DELEGATED HOUSEHOLDER DECISION

The previous drop kerb application, ref. 55611/APP/2020/4318, was refused on the grounds that there was insufficient information regarding potential harm to the street tree in front of the property.

Since this application was determined on 23-03-21, the street tree in question was lost in a storm and cleared by the contractors on behalf of Hillingdon Council. This has been confirmed by Hillingdon Council's Arboricultural Team Manager. The loss of the tree means that the previous reason for refusal is no longer applicable to this proposal for a drop kerb.

SITE PLAN
(SCALE 1:100)

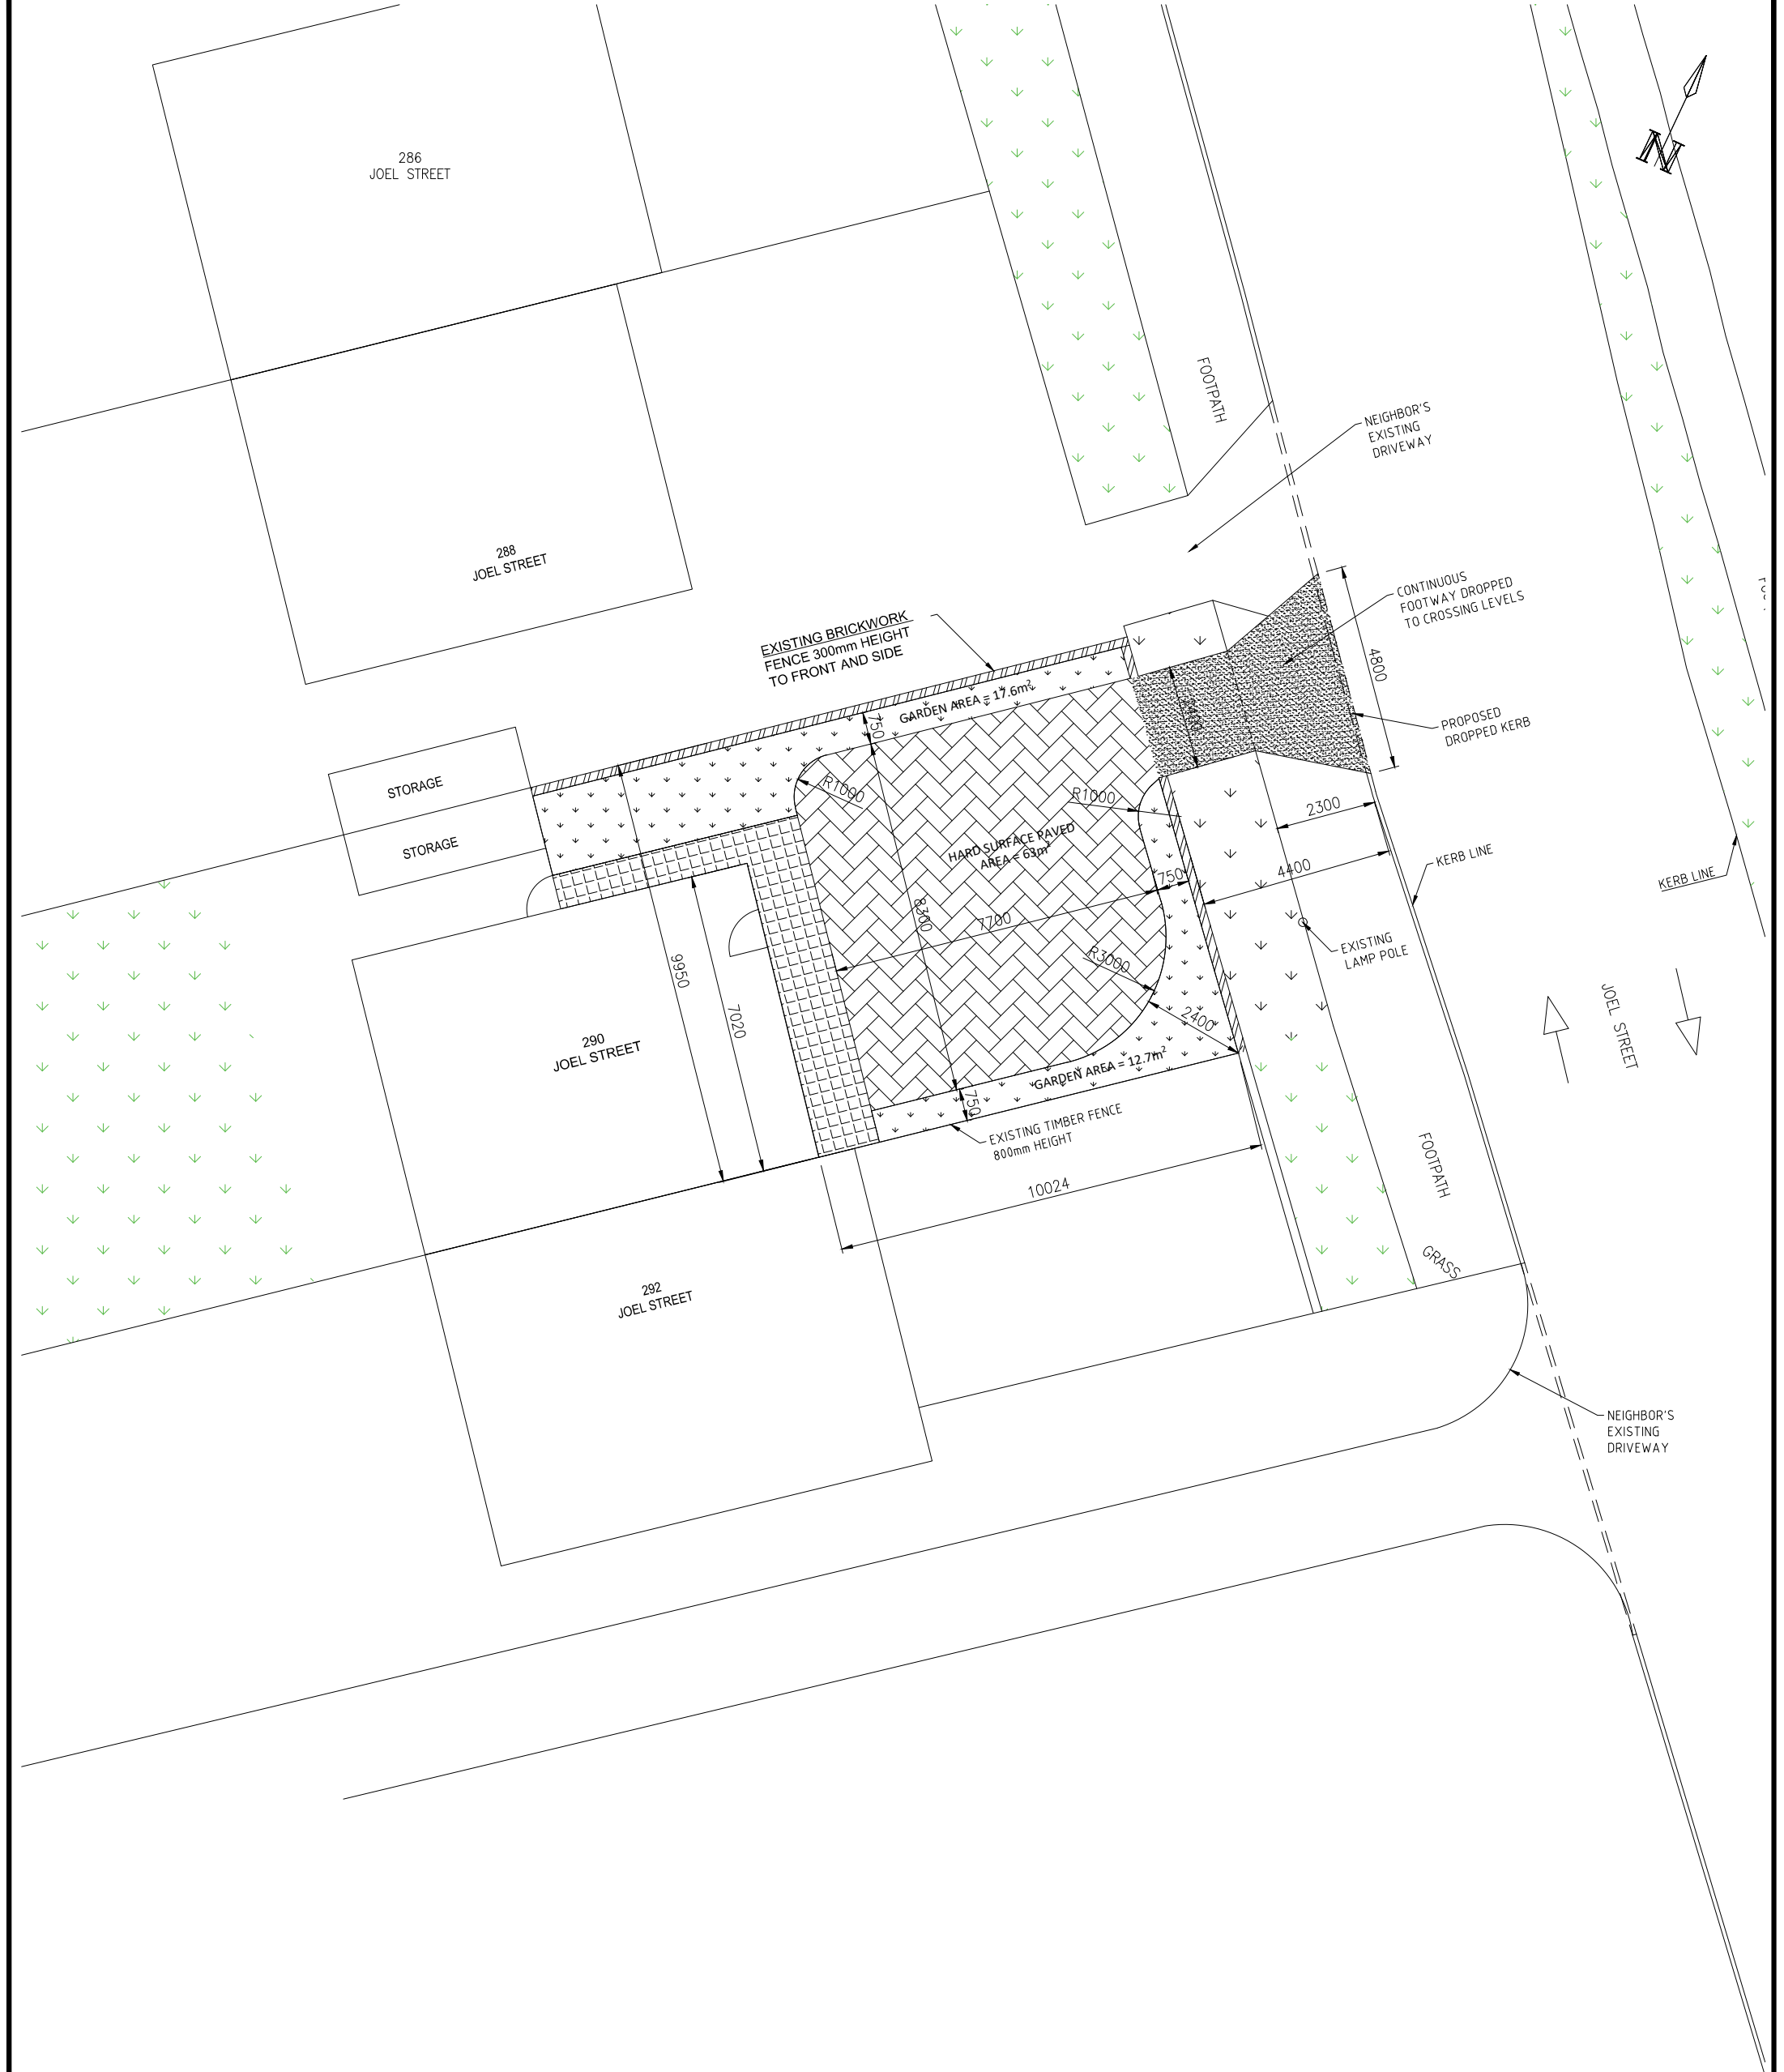
As per the Council's Domestic Vehicle Footway Crossover Policy guidance there must be 1.5 metres gap between the tree and the crossover and the lamp column. The lamp column must be moved to ensure there is 1.5 metre gap on each side of the crossover and the applicant will incur any associated cost to relocate the lamp column.

The proposed development involves the installation of a dropped kerb with paving to the front garden area. The new hard surfacing will cover an area of around 64 sqm, with the total front garden area being around 100sqm. Therefore around 36 sqm of garden will be retained. This is deemed to be acceptable as there is a large amount of hardstanding to front of the neighbouring property at 292 Joel Street. In order to prevent the accumulation of standing water and potential highway safety risks, a condition will be added to final decision notice requiring the materials that will be used to be permeable in nature and retained for the entirety of the developments existence. The drop kerb is deemed acceptable give the presence of dropped kerbs nearby and along Joel Street.

Appendix C of the Hillingdon Local Plan: Part Two - Development Management Policies (2020) requires parking bays to be a minimum of 2.4m x 4.8m. The proposed parking area would measure approx. 4.15m in width and 7.70m in depth meeting this requirement. The highway authority have been consulted on the application and have no objection to the proposed development. As such this is considered acceptable.

Officers comments: It is the applicants responsibility once receiving planning permission to make sure that the lamppost is moved if needed. An informative will be added to the final decision notice reminding the applicant of their responsibilities to seek highway approval for carrying out works on highway land.
